The Executive Committee  
Strata Plan 51487  
Victoria Tower  
197 Castlereagh Street  
Sydney NSW 2000

1 May 2017

**DA/2017/349 – SUBMISSION FOR STATE SIGNIFICANT DEVELOPMENT APPLICATION FOR STAGE 1 CONCEPT APPROVAL FOR THE CONSTRUCTION AND USE OF A 50 STOREY (RL198.22) MIXED USE BUILDING**

Hyde Park - Overshadowing Analysis | Annual Shadow Study

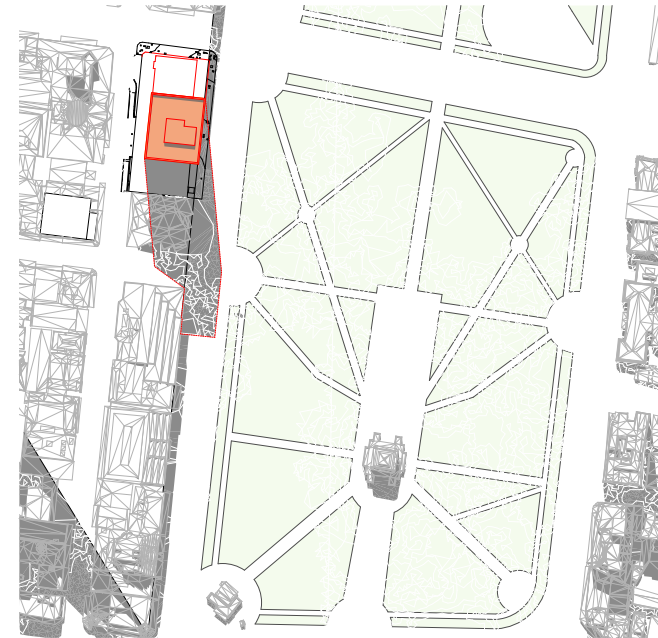
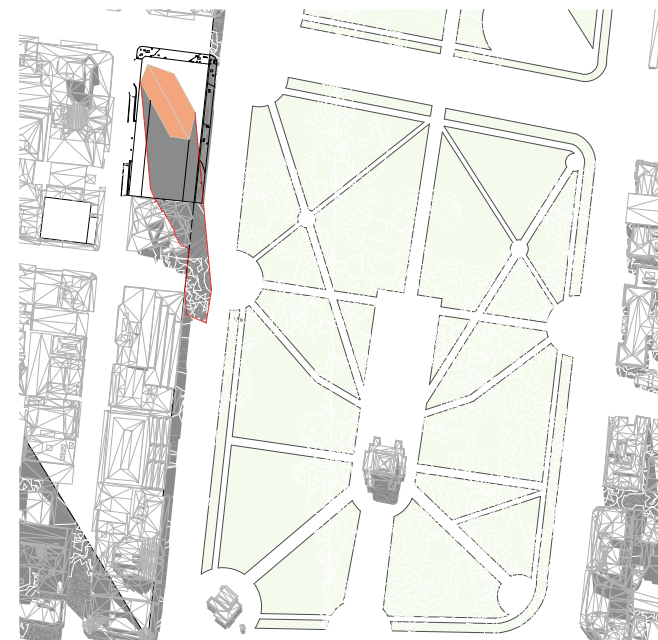
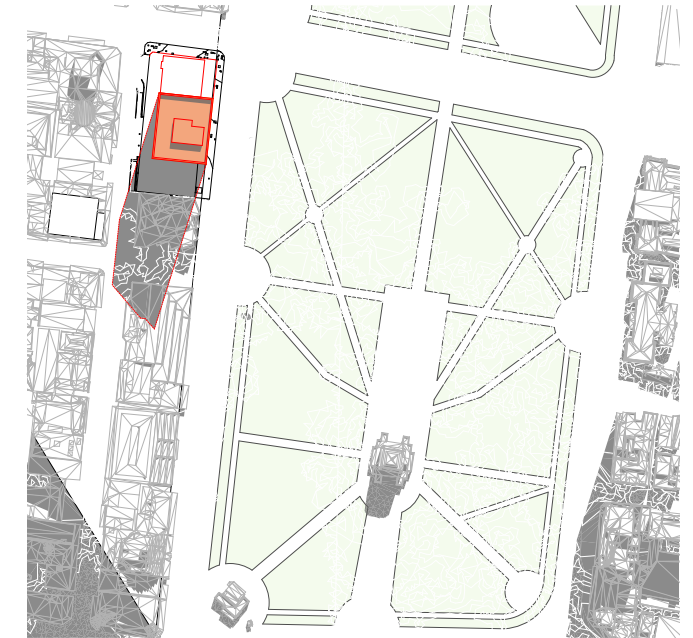
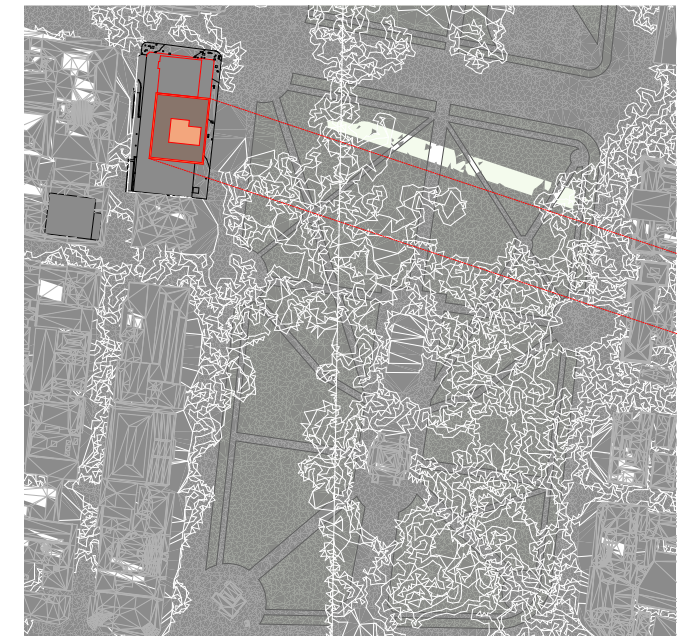
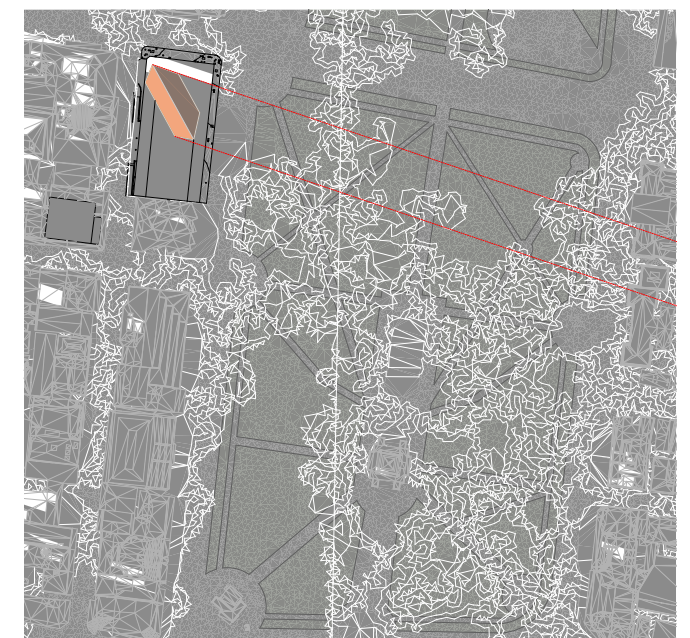
The proposed Northern Tower project is higher than the sun access plane for at least 65% or 70% of its mass. The proposal overshadows Hyde Park including extending almost to the boundary of Liverpool Street, overshadowing the Anzac Memorial and in particular the new additions being constructed to complete the Memorial and also the aboriginal Memorial facing Elizabeth Street

Hyde Park - Overshadowing Analysis | Annual Shadow Study

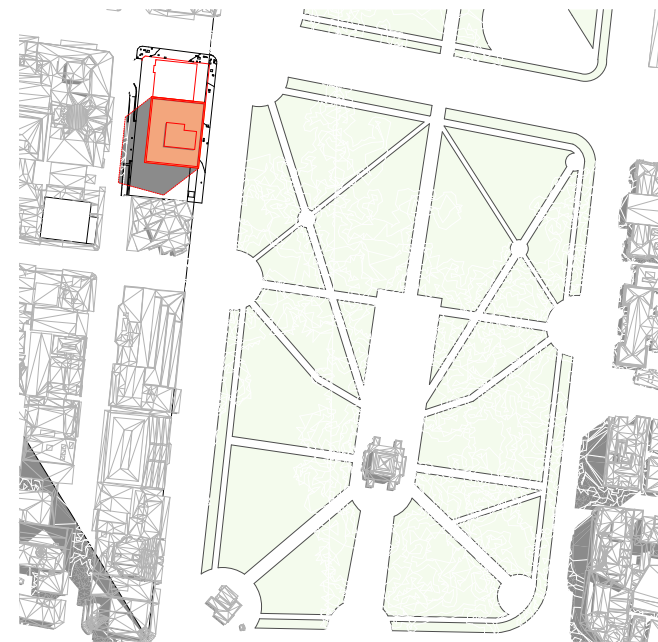
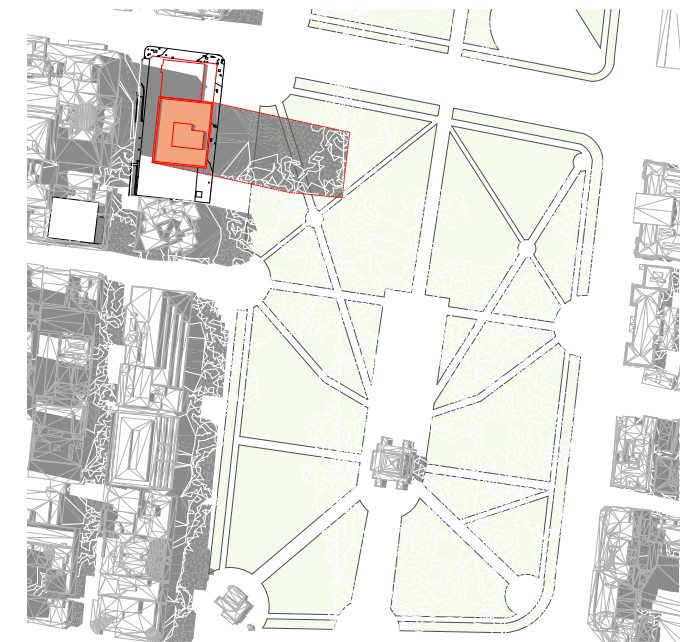
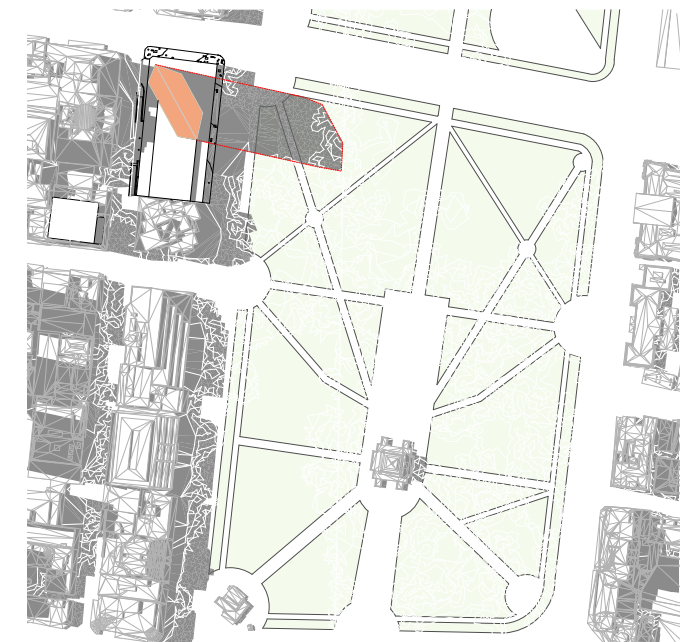
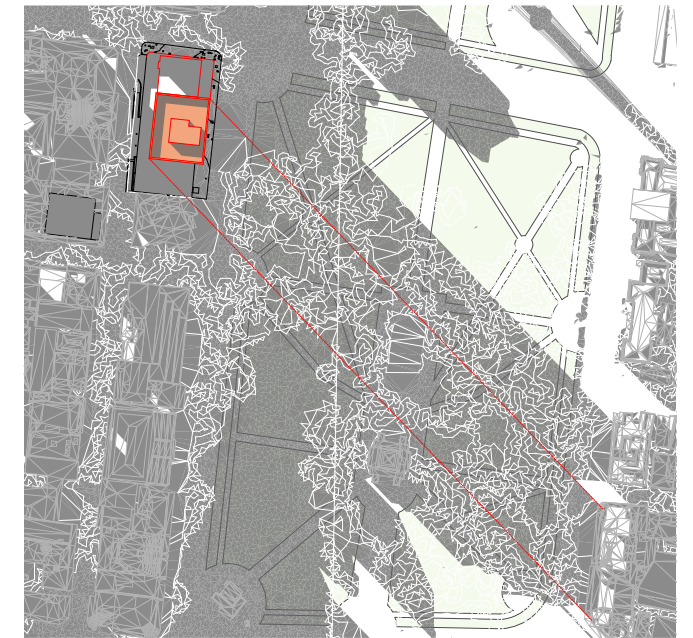
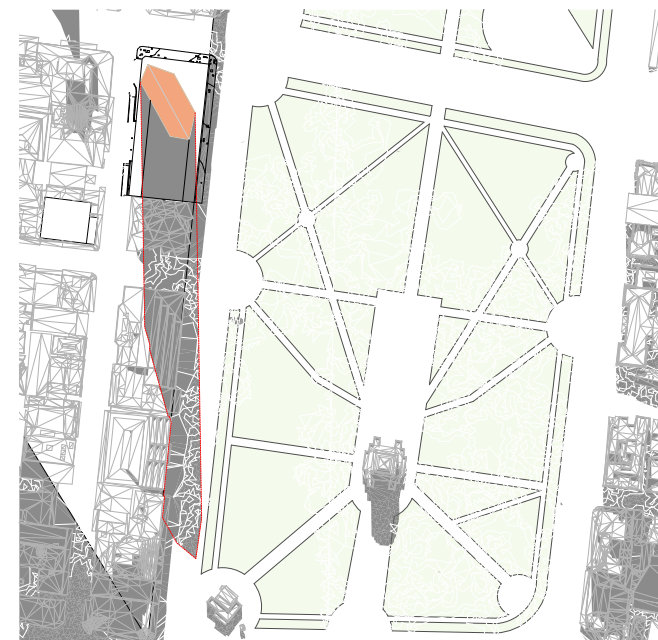
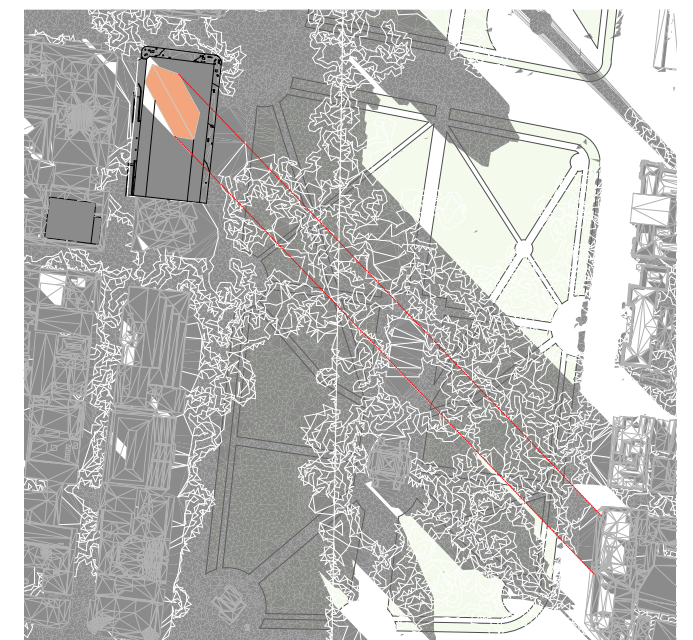
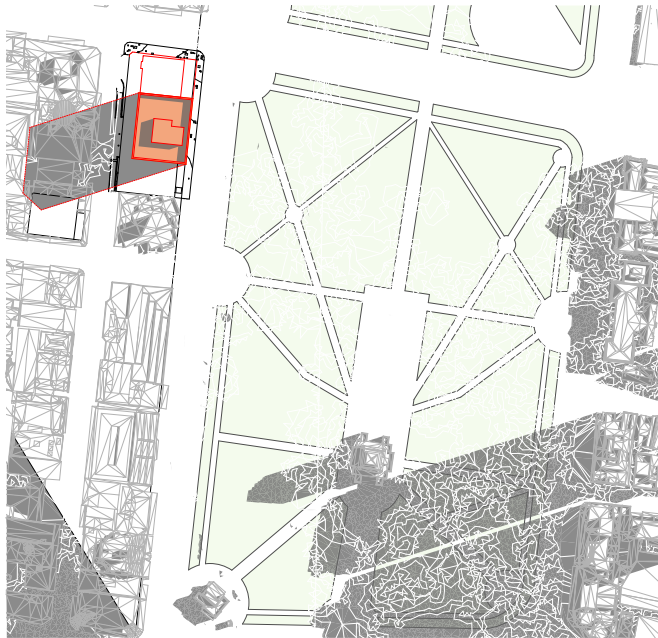
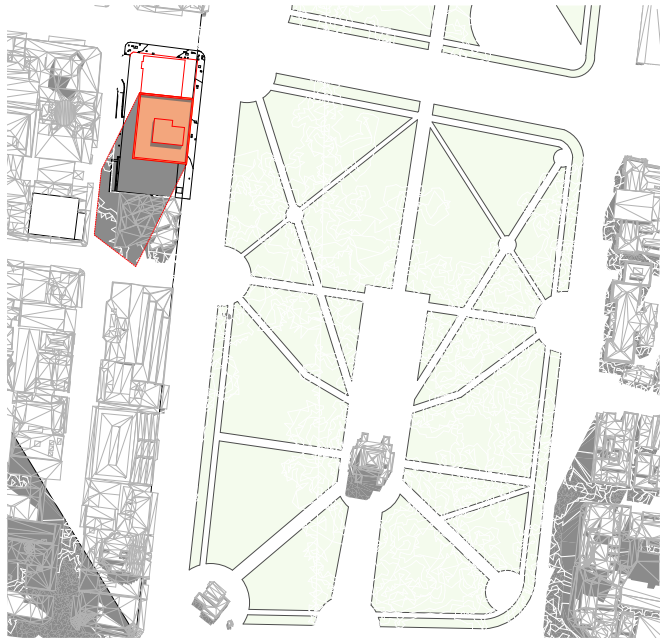
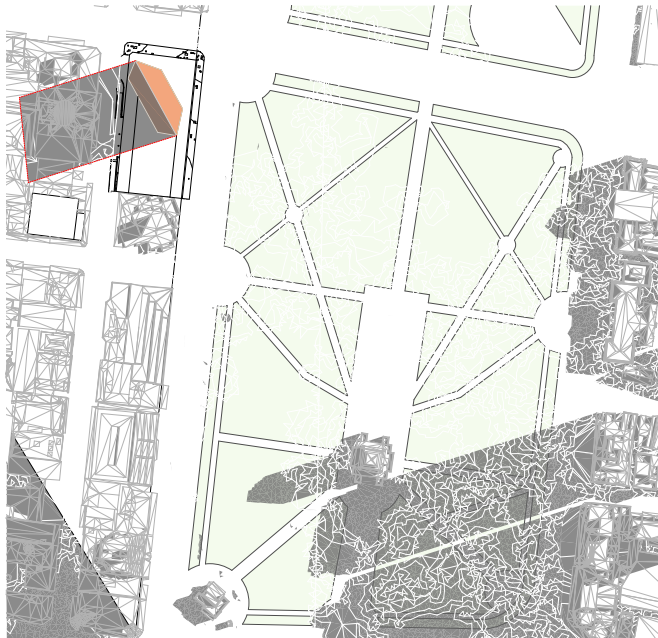
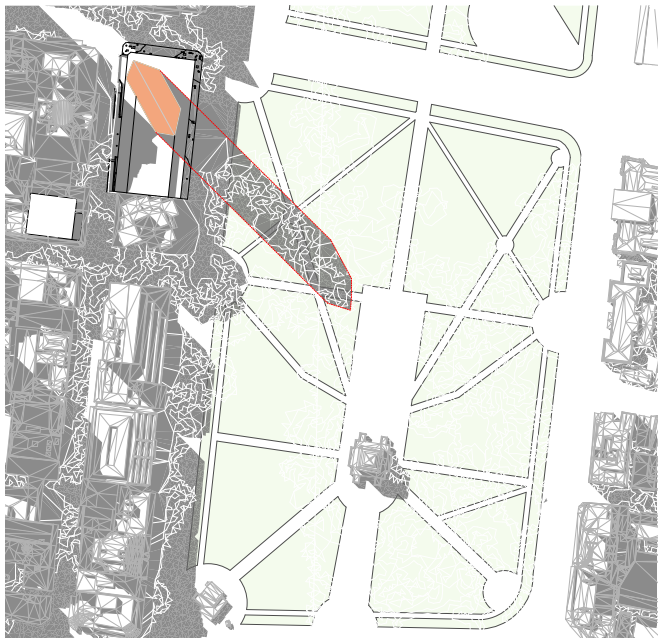
Further, the proponent has failed to provide any calculation or measurement to support the proposition that the new building produces a 50% reduction. Diagrams with the report appear to be inconclusive and show that a reduction in the surface covered by the shadowing occurs, however it is not possible to verify this. In any event, it is submitted that a proper interpretation of the existing clause 6.18 and its objectives would require a 50% reduction in the extent of overshadowing i.e. the distance over the Park, not the footprint of the shadow. It is the overshadowing extending beyond the sun access plane which is the offending issue.
